TURTLE TOWN SHORT PLAT PART OF SECTION 11, T. 20 N., R. 13 E., W.M. KITITITAS COUNTY, WASHINGTON

RE: Turtle Town Short Plat (SP-07-94)

Subject: SP-07-94; Turtle Town Commercial Short Plat (4 Lots)
Lee Frazier, Landowner (24.07 Acres)
I-90, MP 70 (W. Easton Road) Left Vicinity
(East Side of Sparks Road, ~ 0.25 Mile Southeast of Exit 70)

SUBJECT: Turtle Town Short Plat

TURTLE TOWN SHORT PLAT
 PART OF SECTION 11, T. 20 N., R. 13 E., W.M.
 KITTITAS COUNTY, WASHINGTON

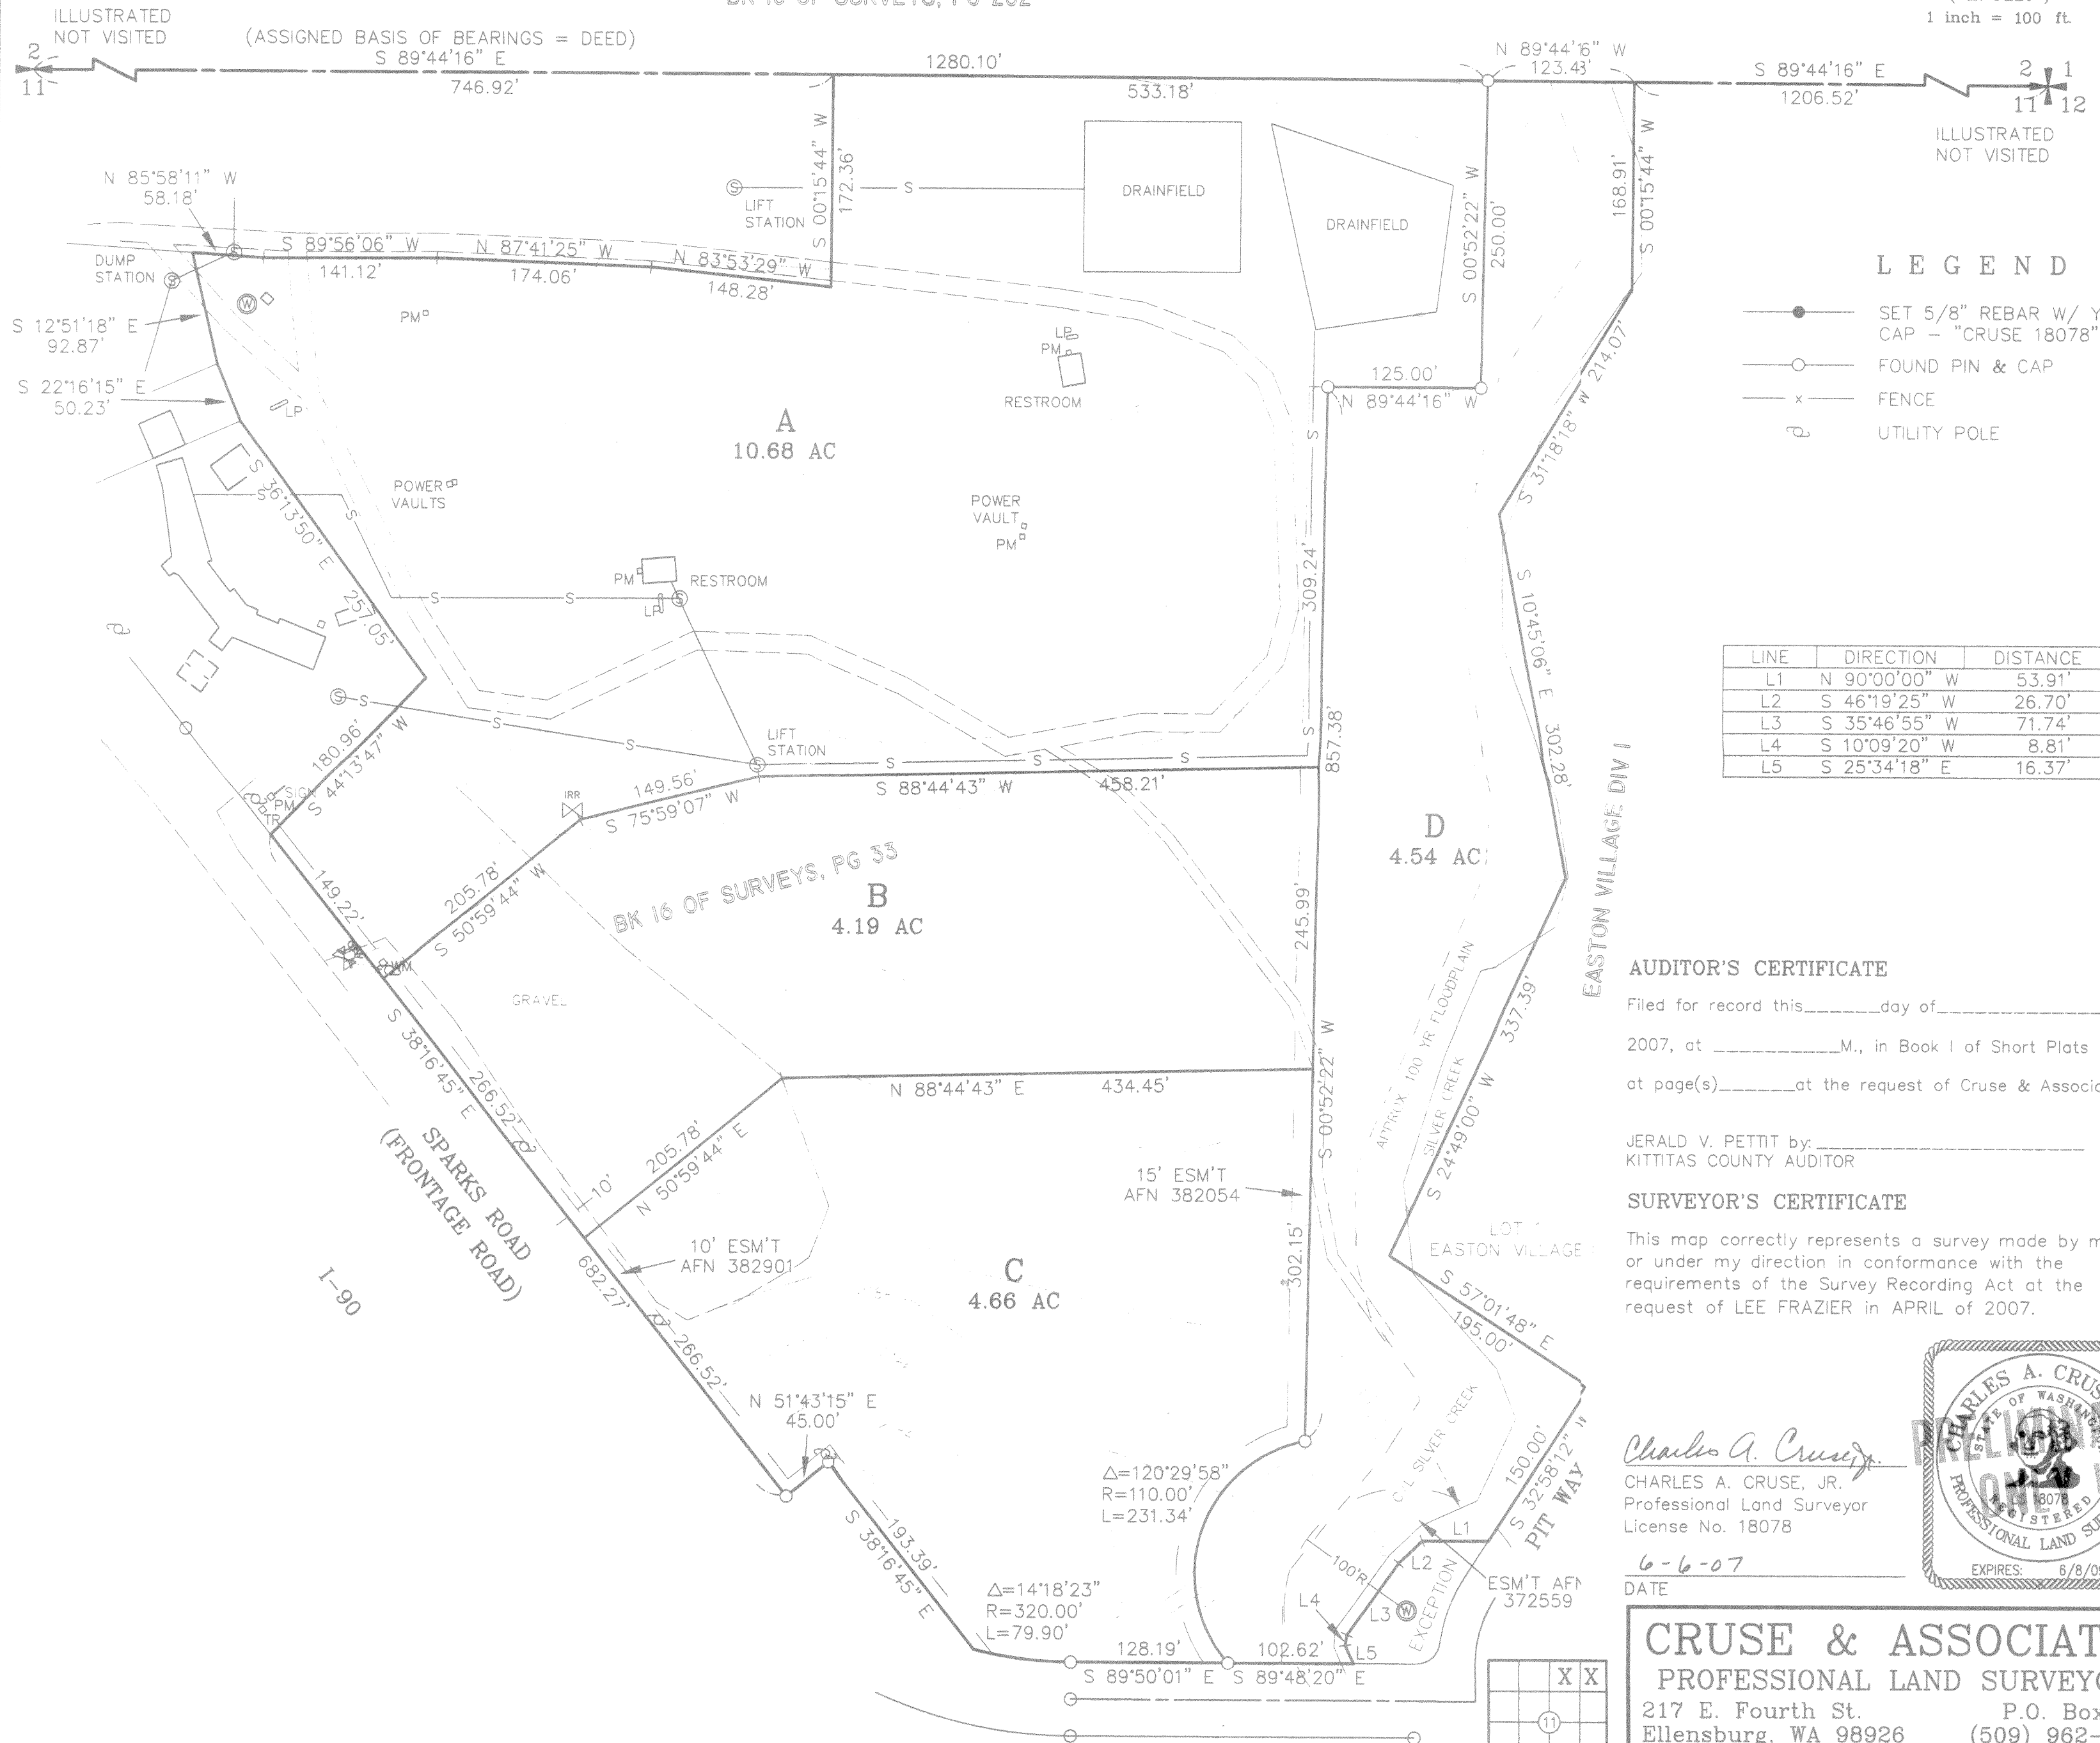
Thank you for the opportunity to comment on the above referenced project. A copy of the well log for the existing well on lot A would suffice for proof of water availability and soil logs are needed for lots B,C and D as there are existing septic systems on lot A.

1. Access to the project site is via Sparks Road and I-90 Exit 70. I-90, including the ramps, is a fully-controlled limited access facility with a posted speed limit of 70 miles per hour. The limited access boundaries extend along Sparks Road. No access is allowed within the limited access boundaries.

3. Access Permit: An approved access permit shall be required from the Department of Public Works prior to creating any new driveway access or performing work within the county road right of way.
4. Access: Each lot fronts Sparks Road. Sparks Road is classified as Rural Local Access and accesses must meet the 100' spacing requirement. At the time of commercial development, additional access improvements may be required.

Joint-Use Driveway: A joint-use access shall serve no more than two tax parcels. See Kittitas County Road Standards, 9/6/05 edition.

- a. Access easements shall be a minimum of 20' wide. The roadway width shall have a minimum width of 12'.
- b. The surface requirement is for a minimum gravel surface depth of 6".
- c. Maintenance of driveway approaches shall be the responsibility of the owner whose property they serve. The County will not maintain accesses.
- d. Any further subdivision or lots to be served by proposed access may result in further access requirements.

Single-Use Driveway: A single-use access shall serve no more than one lot. See Kittitas County Road Standards, 9/6/05 edition.

- a. The roadway shall be a minimum of 8' wide with gravel surface.
 - b. Maintenance of driveway approaches shall be the responsibility of the owner whose property they serve. The County will not maintain accesses.
